**Rix's Creek Extension Project (SSD 6300)**

I refer to your e-mail dated 23 January 2017 seeking advice on the report titled *Rix's Creek Continuation of Mining Project: Response to Submissions Addendum* (21 December 2016). This report provides an assessment of the additional 40.98 hectare area (the Addendum Area) of the project that was not covered in the Environmental Impact Statement (EIS) that was prepared last year. The Office of Environment and Heritage (OEH) notes that the Department of Planning and Environment has requested additional information from the proponent, which is expected around mid-February, and has sought OEH's comments on the addendum report in the interim.

## **ATTACHMENT A: OEH REVIEW OF THE RIX'S CREEK CONTINUATION OF MINING PROJECT: RESPONSE TO SUBMISSIONS ADDENDUM**

Figure 1 Location of the Rix's Creek mine: lease area, existing mine approvals and proposed Rix's Creek Continuation Project.

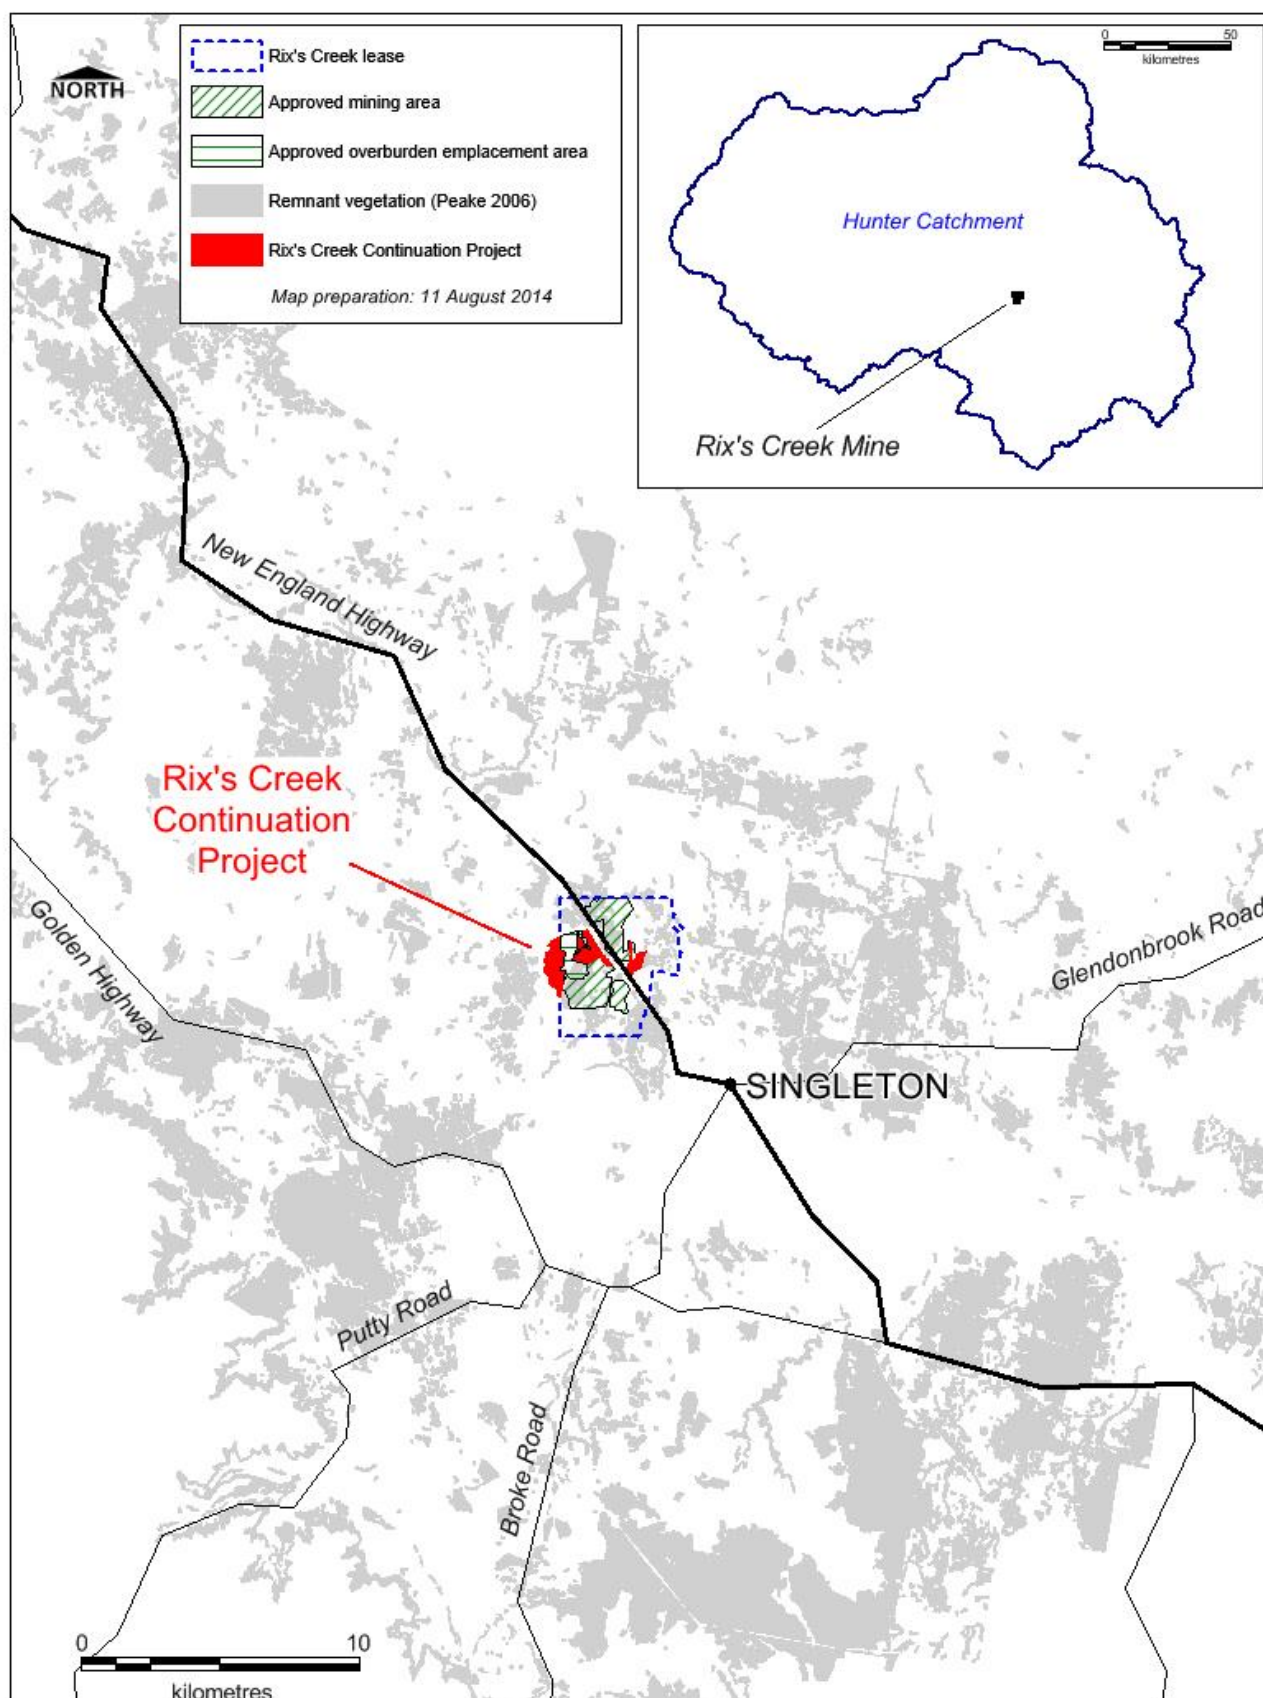
Figure 1 does not clearly explain the areas that correspond to the Central Hunter Valley eucalypt forest and woodland. The area of Central Hunter Valley eucalypt forest and woodland has not been stated so this requirement has not yet been met.
